Our Ref: HE551519-ATK-GEN-LN-XM-000011

10 March 2021

M25 junction 28 improvement scheme
Planning Inspectorate reference: TR010029
Notification of intention to make a request for additional changes to the
Scheme (Changes 5-7)

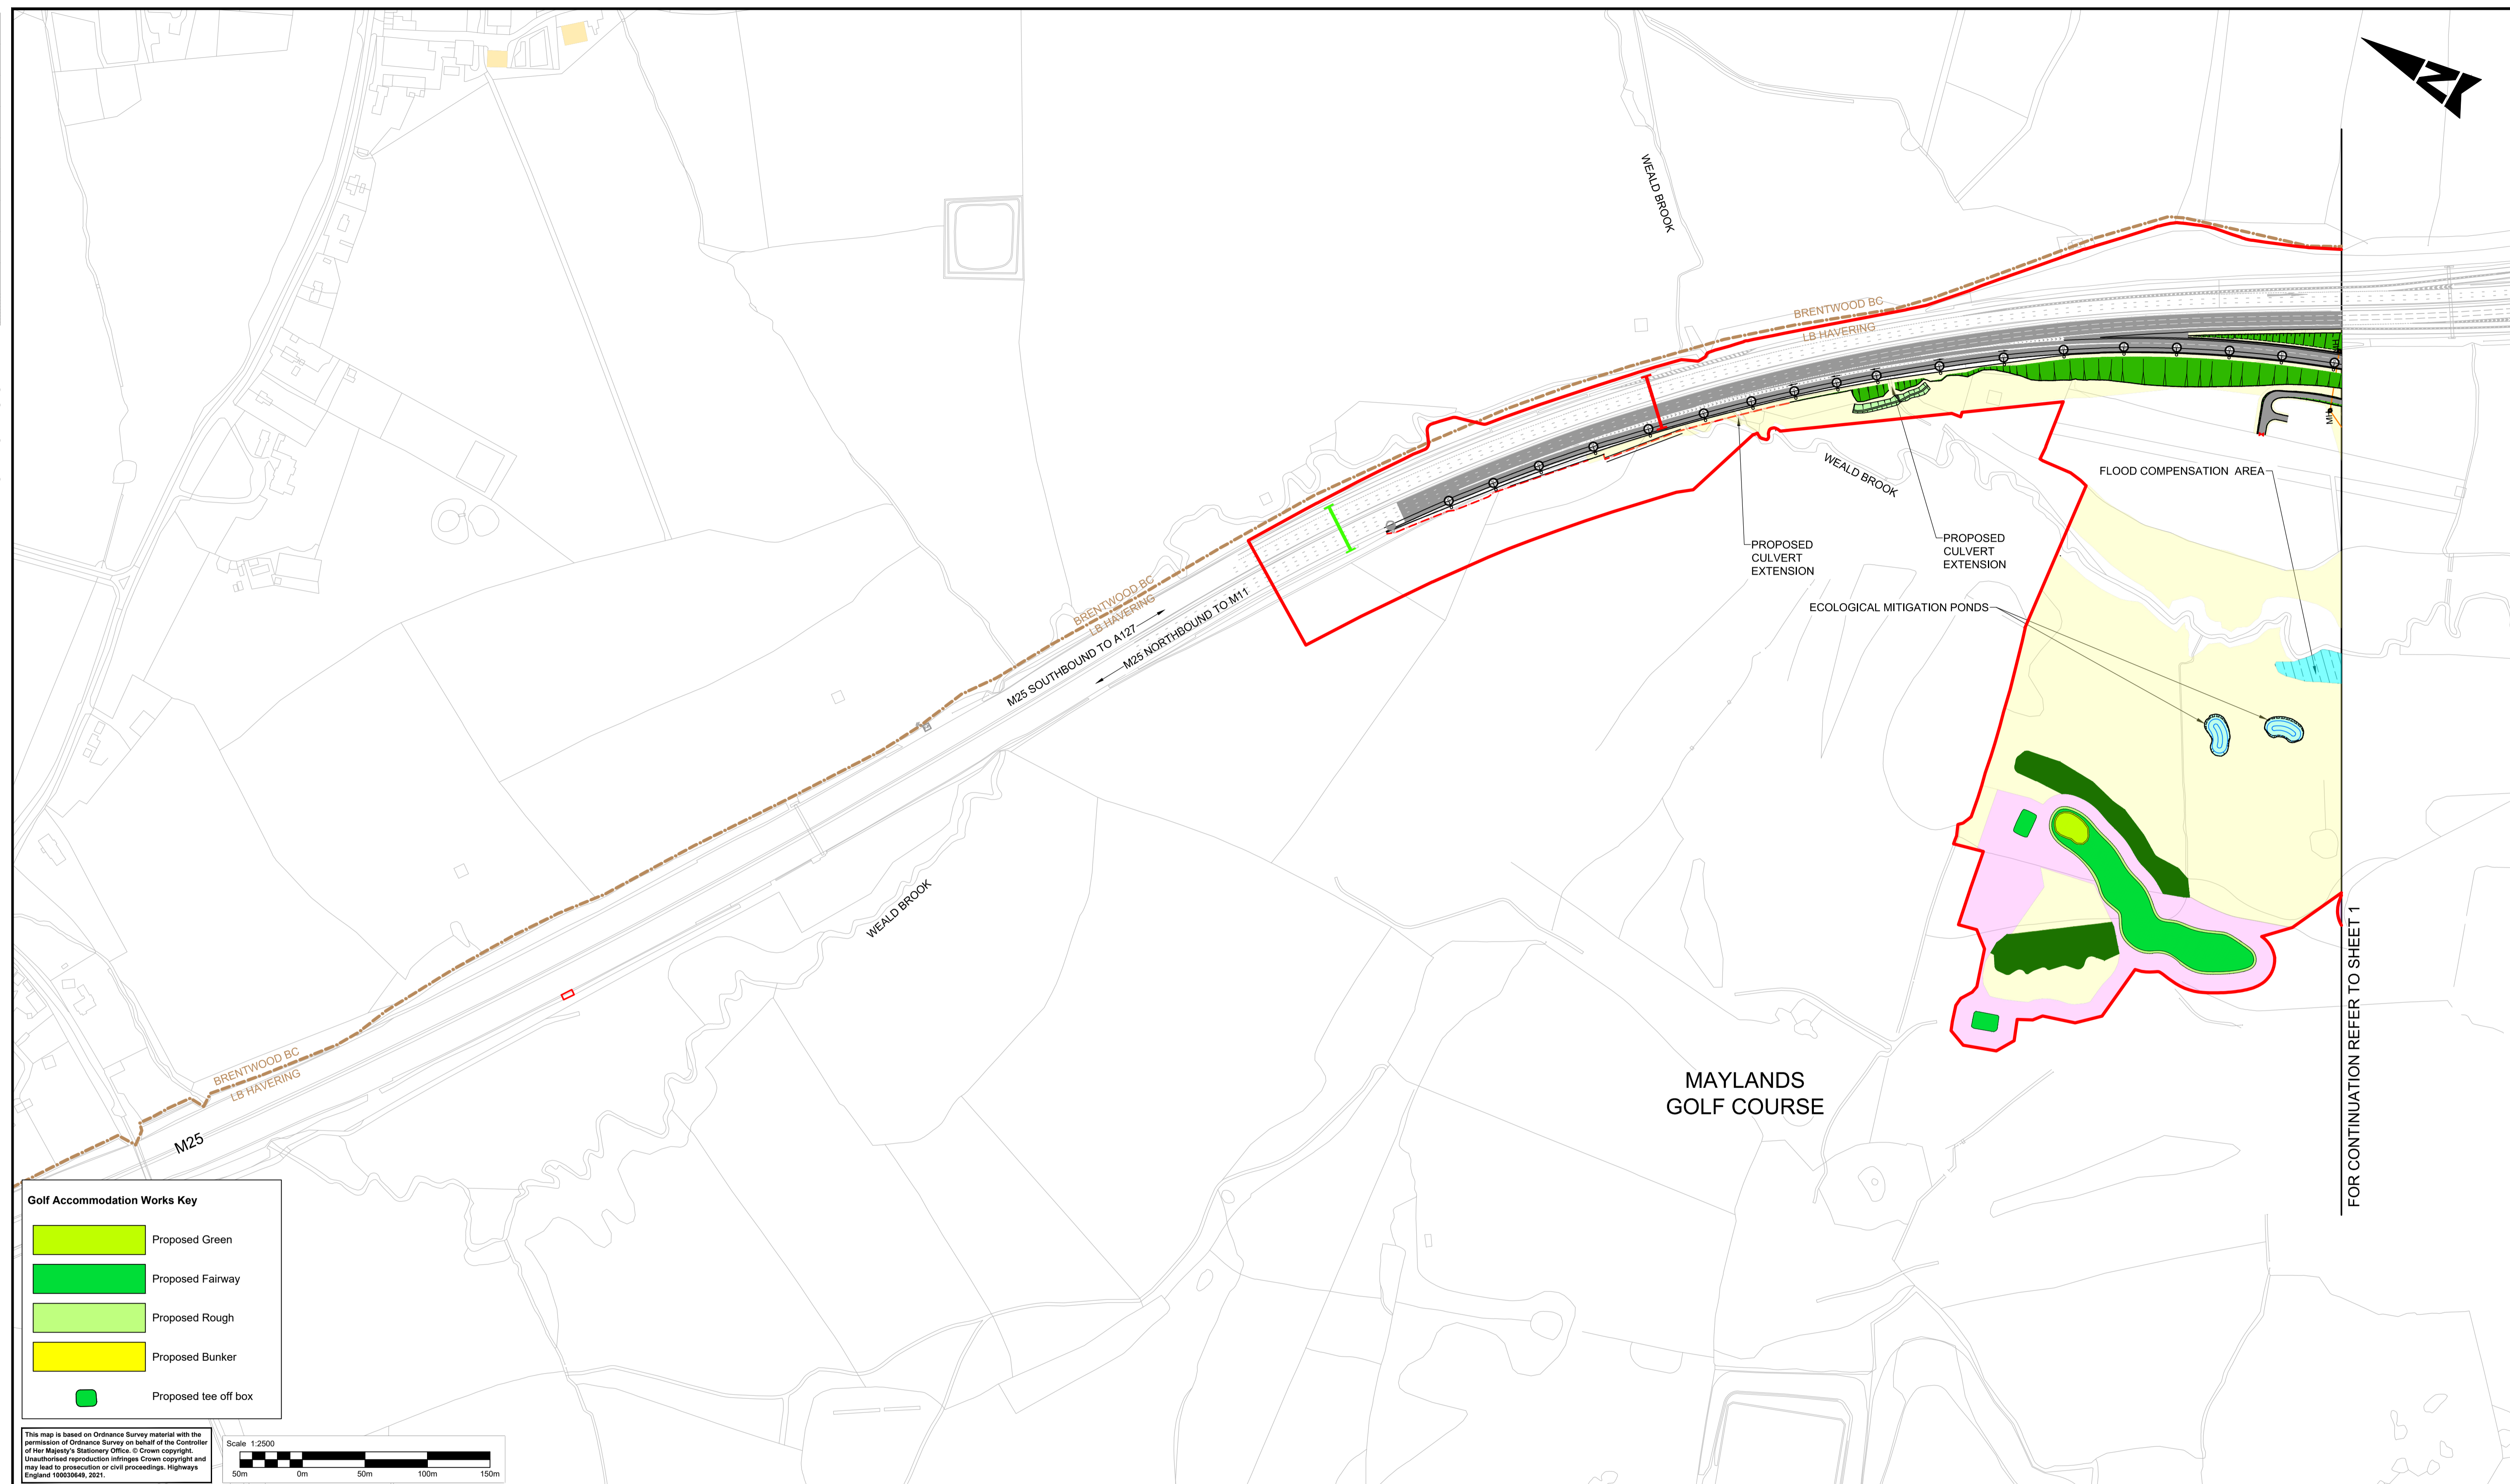
Change 7 – Refinement of Maylands golf course accommodation works (Work No. 32)

Change 7 is a refinement of the golf course accommodation works (Work No. 32) to accommodate an alternative design for replacement hole 2, associated remodelling, landscaping and other related works. This change follows continued discussions with Luddington Golf Ltd, which included reviewing the information provided as part of their Written Representations [REP2-032] together with that received from the landowner, Glebelands Estates Ltd [REP2-031].

existing layout at Maylands Golf Course. As a result, an alternative solution for the redesign of the relevant part of the golf course is proposed, and further details of this will be included in the consultation materials being prepared in relation to these changes.

Change 7 would require an extension to the Order limits in the Application to include additional land occupied by the golf course. The additional land is only needed on a temporary basis. Highways England does not need to acquire it or rights in it. Accordingly, The Infrastructure Planning (Compulsory Acquisition) Regulations 2010 (the 2010 Regulations) would not be engaged.
